**EL PASO COUNTY DEVELOPMENT SERVICES DEPARTMENT
SIGN APPLICATION**

Name: Arimag Construction
Address: 7302 Cole View
Colorado Springs, CO 80915

Zone: CS CAD-0
Legal Description:
LOT 22 CLAREMONT
BUSINESS PARK FIL NO 2

SOUTH-WEST ELEVATION

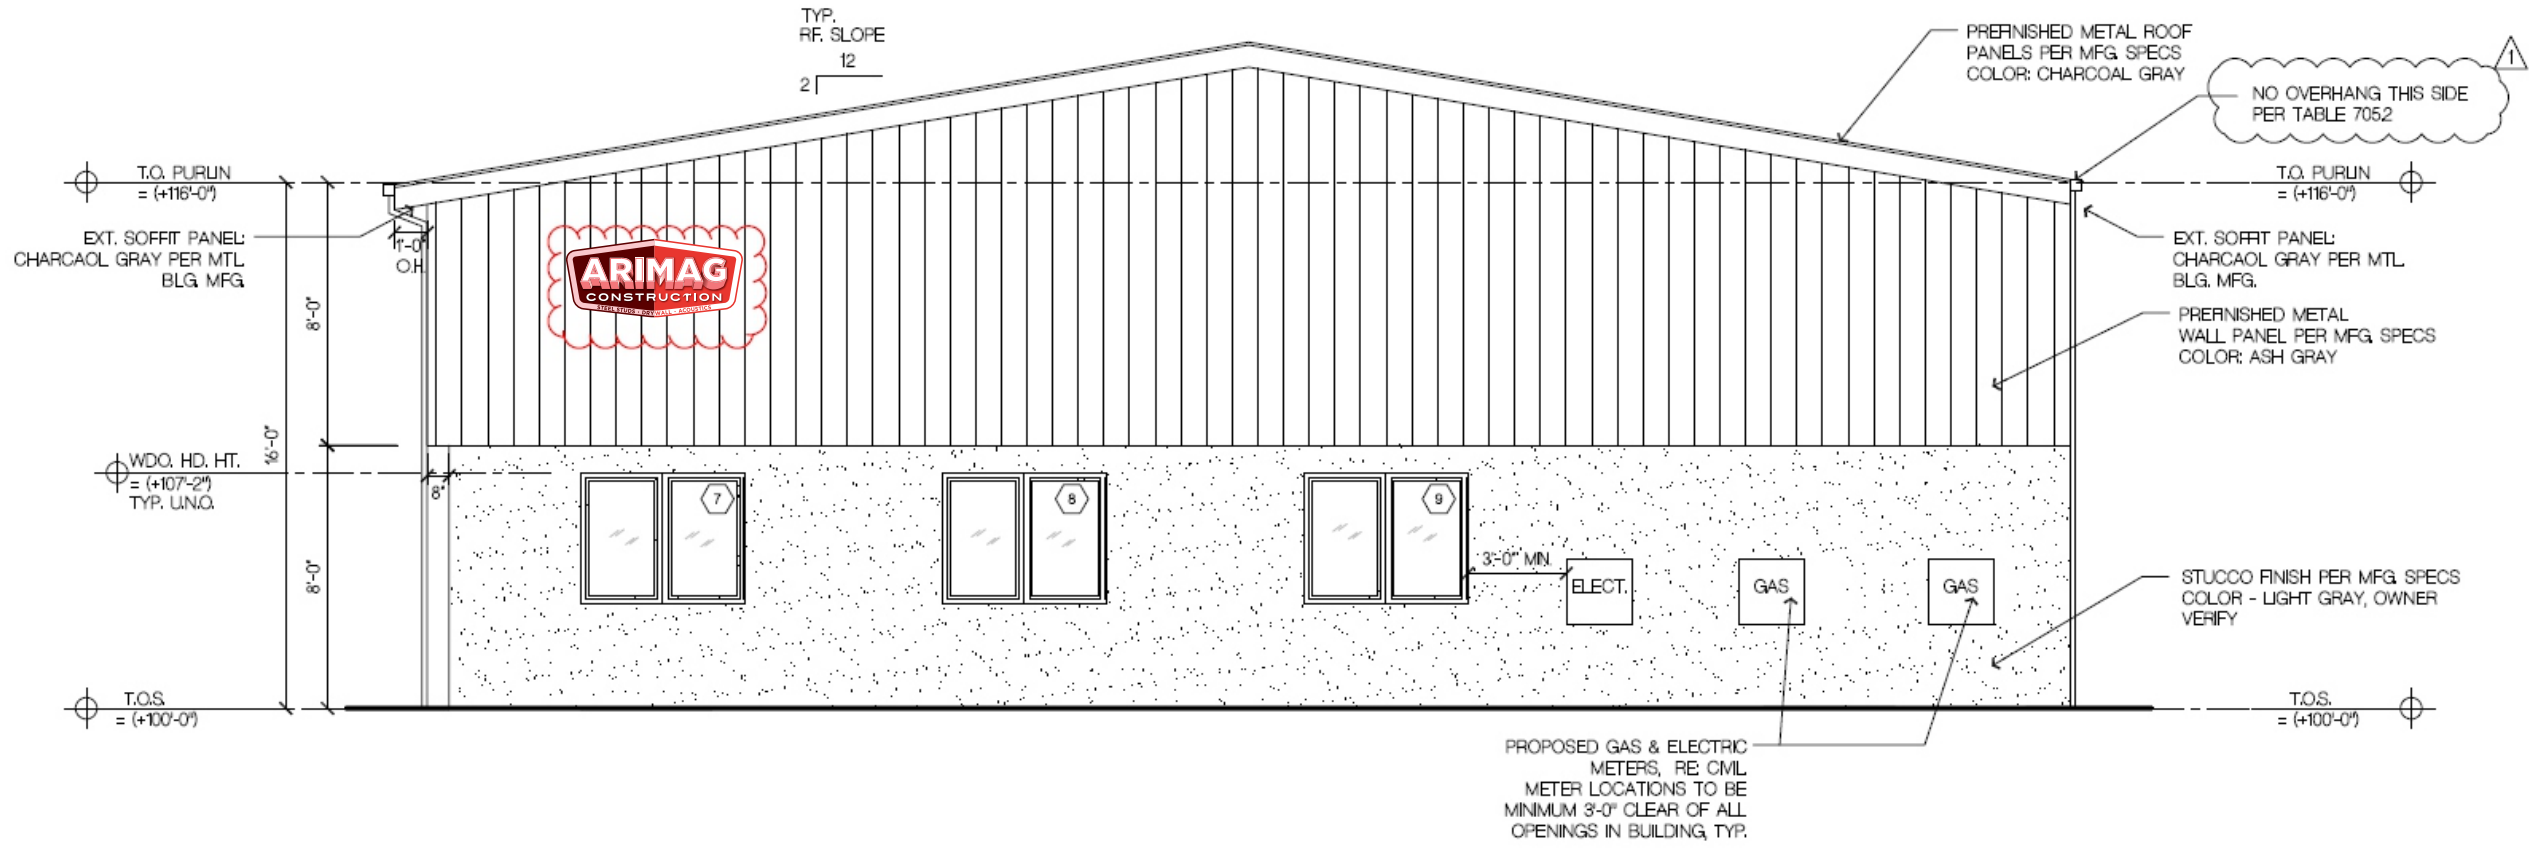
Ensure that illumination is steady and adequately shielded such that no direct lighting is projected off-site. Maximum on-site lighting shall not exceed 10 foot candles. Light level at edge of property adjacent to public right of way shall not exceed 0.1 foot candle.

Indicate storefront length & placement of sign.
